Planning Application Reference No.: 3/2026/0516

Address of Development: 17 Elm Tree Grove Brockhall Village Old Langho BB6 8HP

Location Plan

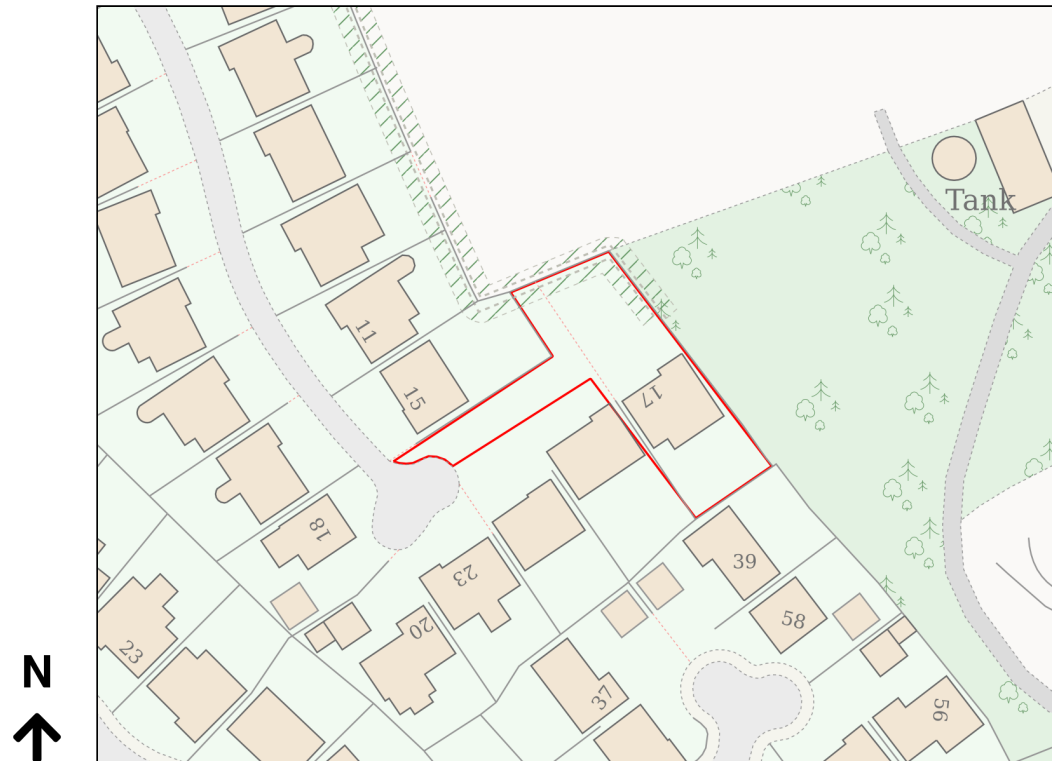
Comments: The site location plan implies that there is a hard standing at the end of the garden at [REDACTED]. This is not a hard standing but a landscaped area with trees as identified in the original planning permission to soften the impact of this towering building at the bottom of the Garden. This planning application appears to be putting forward an attempt to change this agreement by placing a hard standing instead of the landscaped area. Please clarify that this area will remain as a landscaped area and not changed from the original planning approval.
